Application Number: S6/2013/1338/FP
Name: Richard Stratton

Address: 70 Walker Grove, Hatfield, AL10 9PL Comment Type: Object
Comment: Using the council's Houses in Multiple Occupation Supplementary Planning Document as a guide my complaint is based on 3 criteria highlighted in that document.

Ground Floor Plan- Proposed

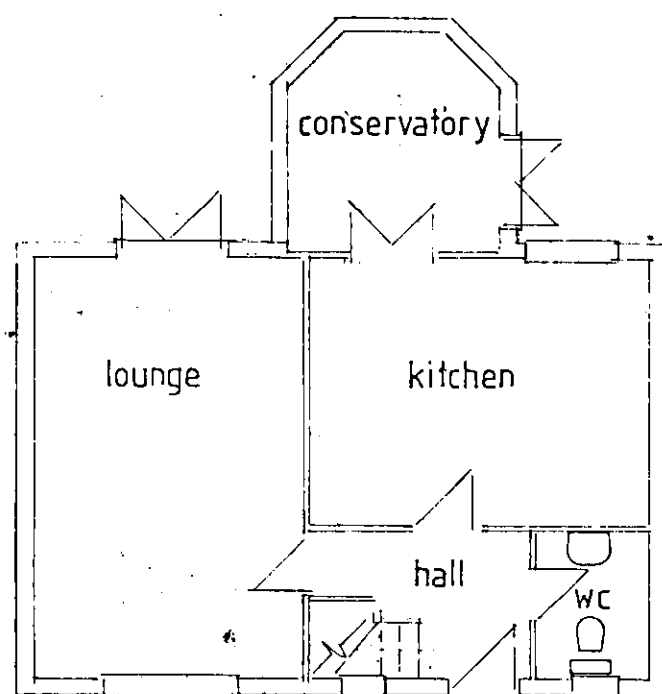
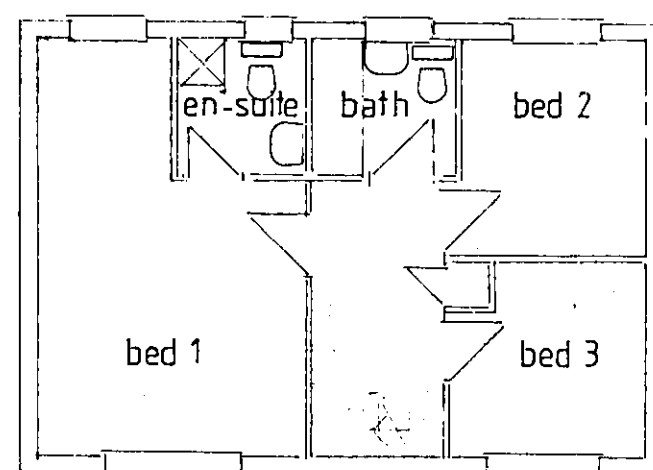
Criterion HMO5: Layout and Design a. Internal Layout Standards The planning application has requested consideration for 6 units and that the ground floor lounge be converted to a bedroom.

Criterion HMO5 states that It is expected that all houses in multiple occupation will normally have at least 1 communal room; and that a 6 unit HMO property's Communal Room (Living or Dining) must be at least 12.5 square metres. The conservatory is the only applicable communal room in the property (given the lounge's conversion to

a bedroom). The conservatory is approximately 7.8m square metres, smaller than the size stipulated by the council.

BLOCK PLAN
AREA 90m x 90m
SCALE: 1:500 on A4
CENTRE COORDINATES: 520762 , 208967

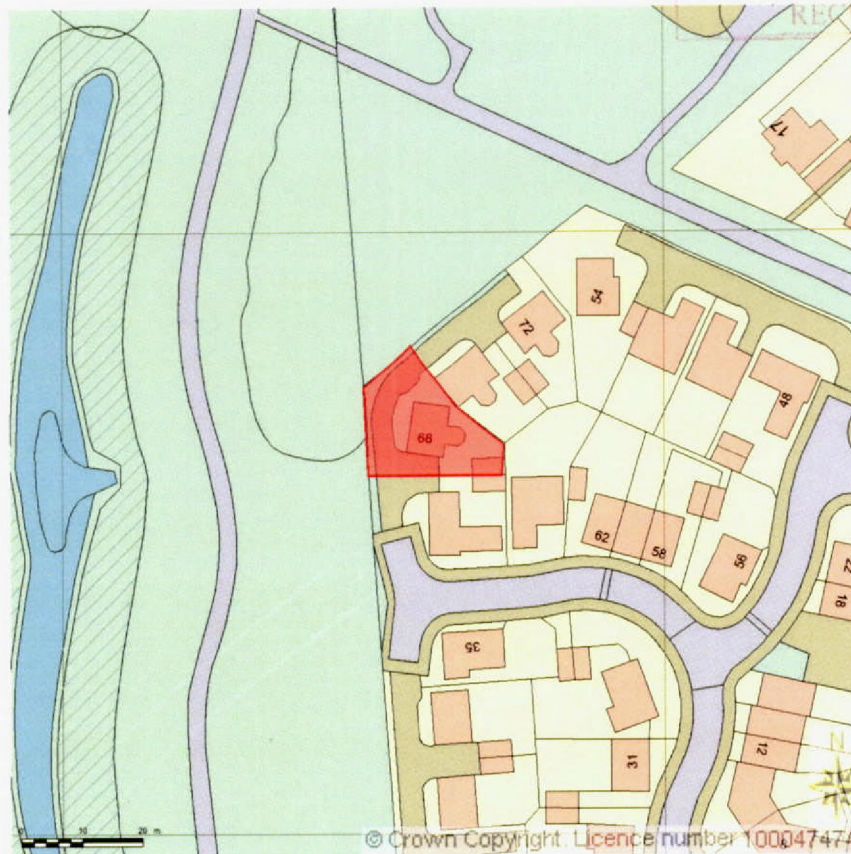
The application has specified that there are 4 parking spaces. I believe this to be the narrow lay-by area on the north-west of the property (Space 1), two spaces immediately in front of the garage parallel to the southern wall of the property (Spaces 2 and 3) and the garage (Space 4). For a 6 unit HMO, the council requires at least 3 parking spaces to be available at the property.

Criterion HMO2 states that all car parking spaces should be capable of being used independently of one another. If the space immediately in front of the garage is occupied (Space 3) then the car parked in the garage is unable to be used independently. If Space 2 (immediately in front of Space 3) is occupied then neither the car in Space 3 nor the car in the garage can be used independently. This means that the available parking at the application property can only allow 2 cars to be parked and subsequently used independently of each other (the lay-by and one of Space 2, Space 3 or the garage). Two parking spaces falls below the minimum number of permissible parking spaces required of a 6 unit HMO. In theory, a car could use the garage and a second car could park in Space 2, but the car in the garage could only be used independently if it used 66 Walker Grove's driveway for access, and I assume that is not permissible.
